Fire Marshal Division

RE: Napper Tandy
27 S Broad St.
Angier, NC 27501

Application Number FMFW2103-0006

Drawing for;
Napper Tandy's
27 S. Broad St. East
Angier, NC 27501

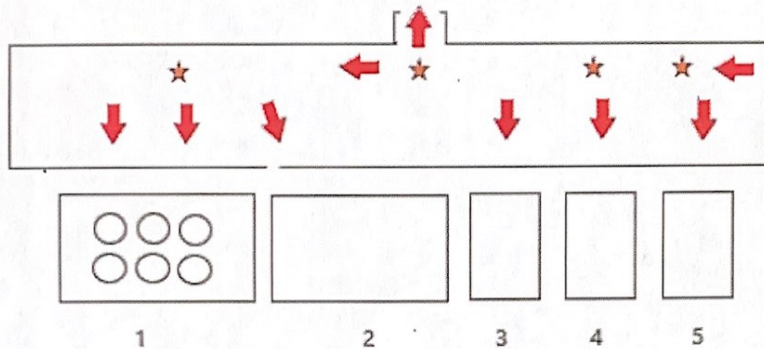
A manual actuation device shall be located at or near a means of egress from the cooking area, a minimum of 10 feet (3048 mm) and a maximum of 20 feet (6096 mm) from the kitchen exhaust system. The manual actuation device shall be located a minimum of 4.5 feet (1372 mm) and a maximum of 5 feet (1524 mm) above the floor. The manual actuation shall require a maximum force of 40 pounds (178 N) and a maximum movement of 14 inches (356 mm) to actuate the fire suppression system.

System Interconnection of Commercial Hood System

- The actuation of the fire suppression system shall automatically shut down the fuel or electrical power supply to the cooking equipment. The fuel and electrical supply reset shall be manual.

FLOOR PLAN
1/4" = 1'-0"

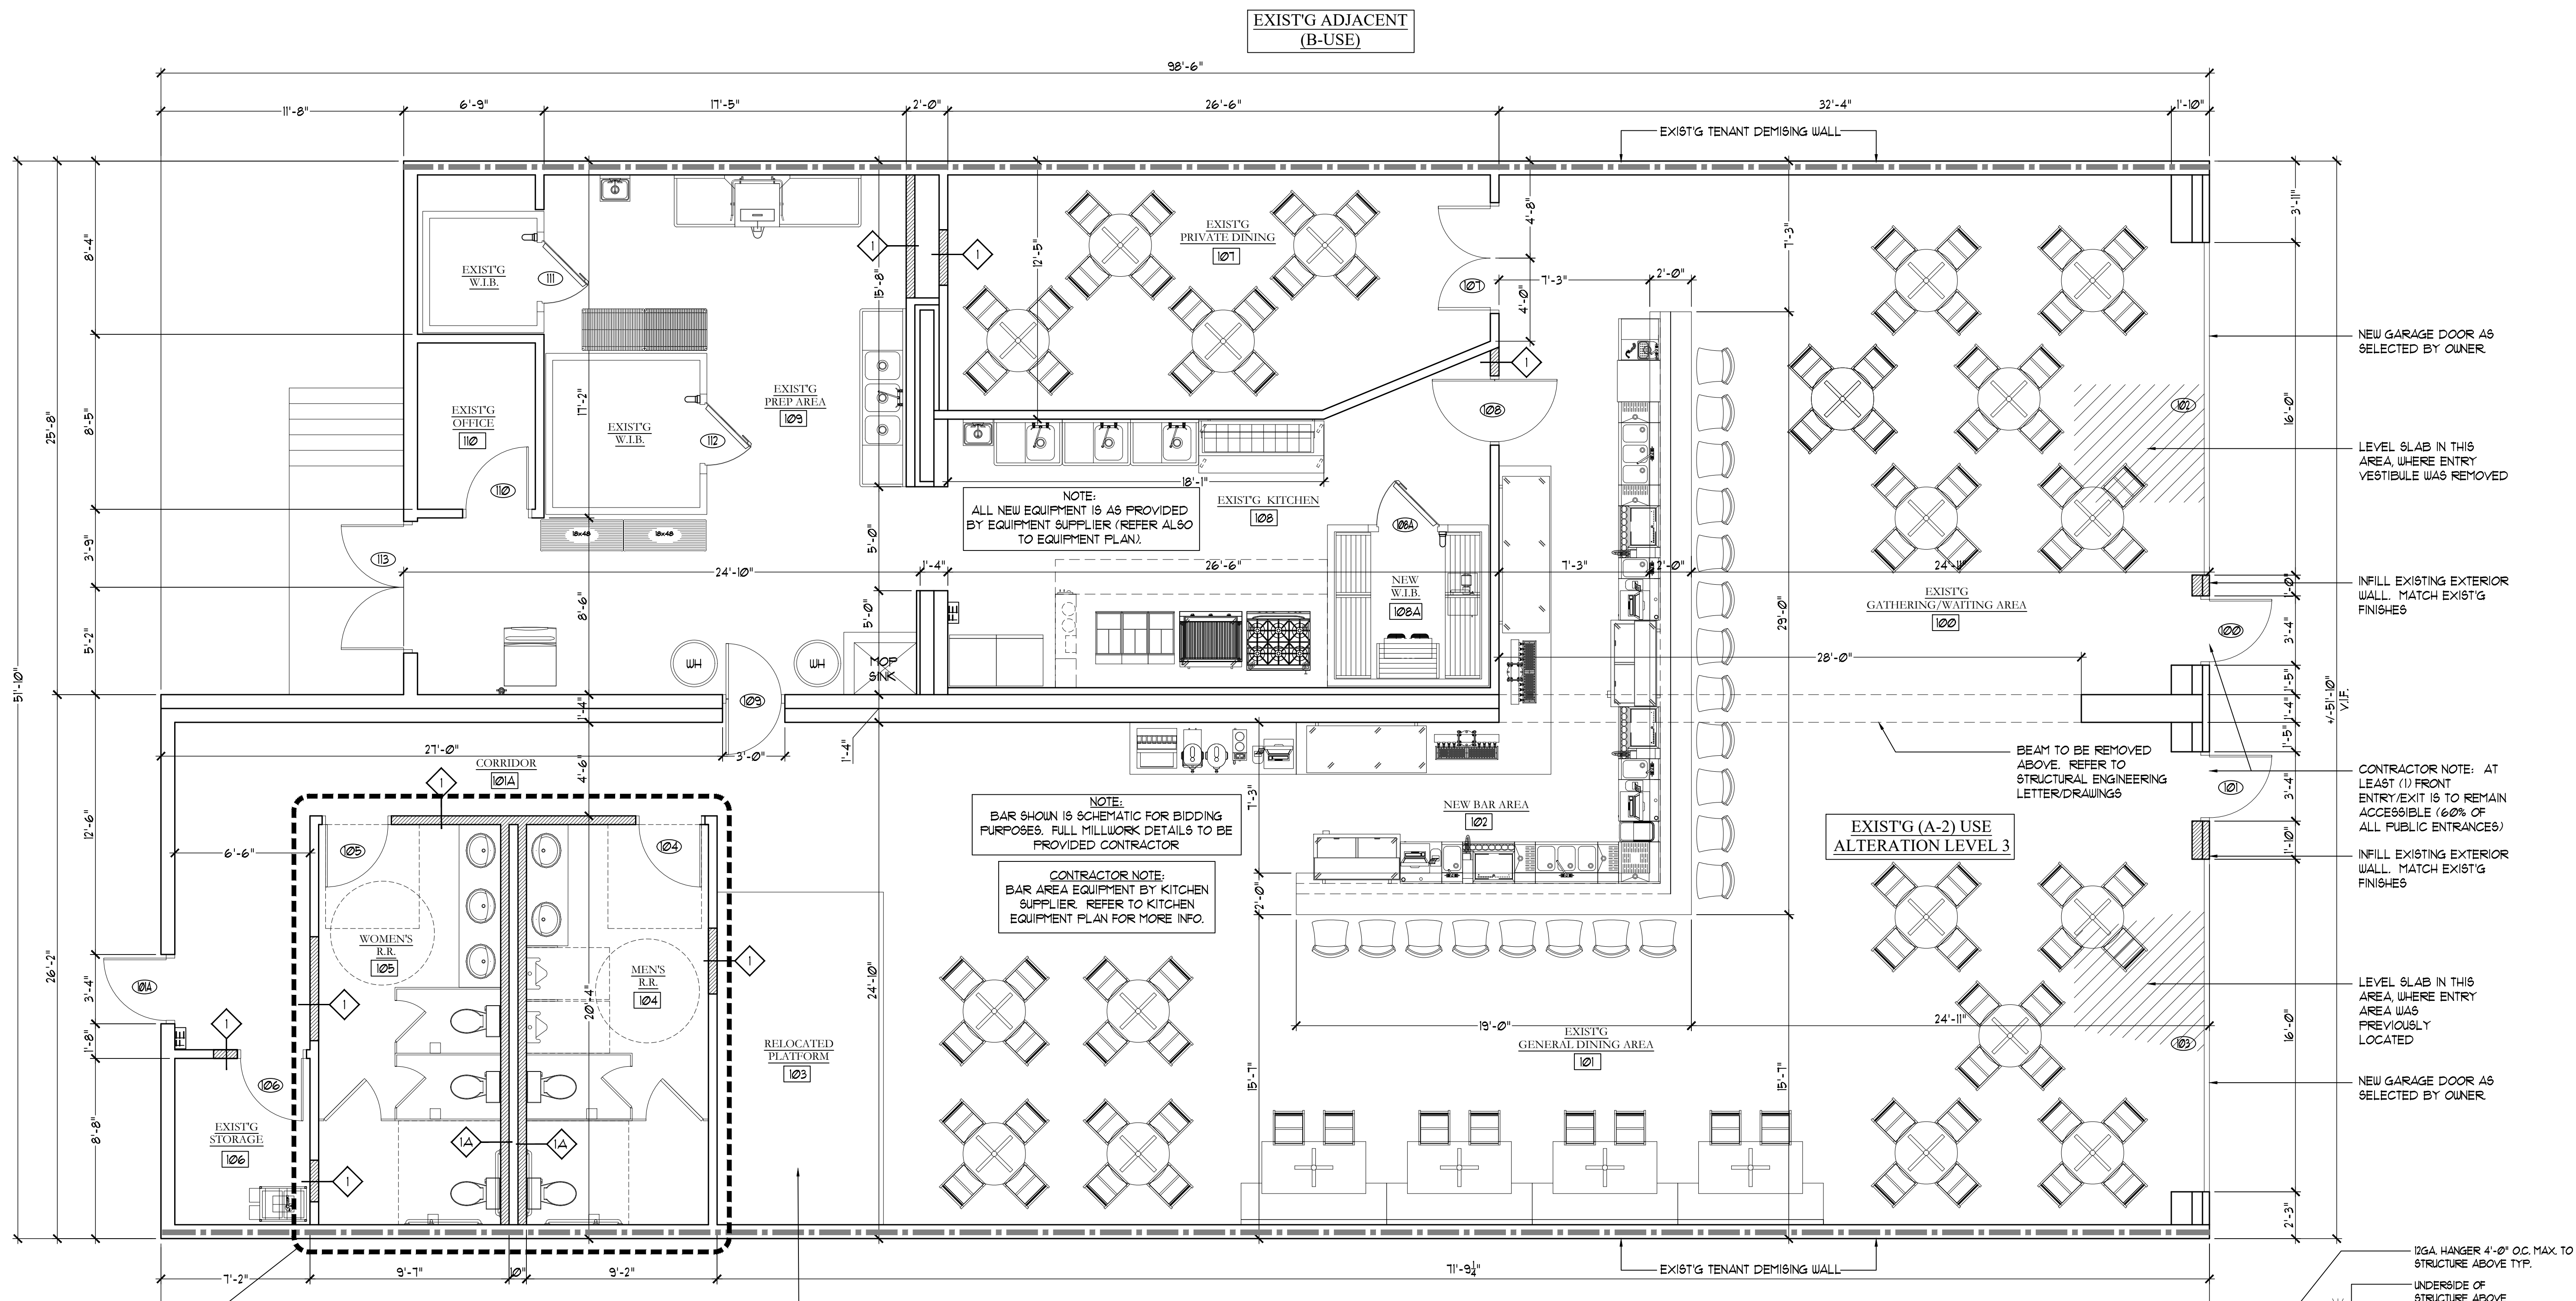
- **906.1 Fire Extinguishers**
 - Fire extinguishers shall be placed in approved locations, one in the area of the rear storage space and one in the front entrance area.
 - The fire extinguishers provided shall have a minimum rating of 2A 10B: C and shall not be installed higher than 5 feet above the finished floor.
 - In addition to the above extinguishers, a portable fire extinguisher shall be provided within a 30-foot (9144 mm) travel distance of commercial-type cooking equipment. Cooking equipment involving vegetable or animal oils and fats shall be protected by a Class K rated portable extinguisher.

- **506.1 Knox Box**
 - Keys for front entrance door shall be provided to be placed in the existing box installed on the premises.

- The numbers used to make up the physical address shall be at least 6 inches in height with a minimum stroke width of $\frac{3}{4}$ inch.
- The physical address needs to be posted on the rear of the building also.
- **Panic Hardware**
 - UL 305 listed panic hardware is required on exit doors serving a room/space with an occupant load >50, also indicated on Building code summary. Panic hardware is not included on door schedule sheet B8 of Drawings.
- **Acceptance Test of Commercial Hood System**
 - An acceptance test will be conducted by the Fire Marshal's office once system has been installed and pre-tested.
 - Installation shall be per architectural and system submittals and compliant with NFPA-17A.
- **Manual system operation of Commercial Hood System**
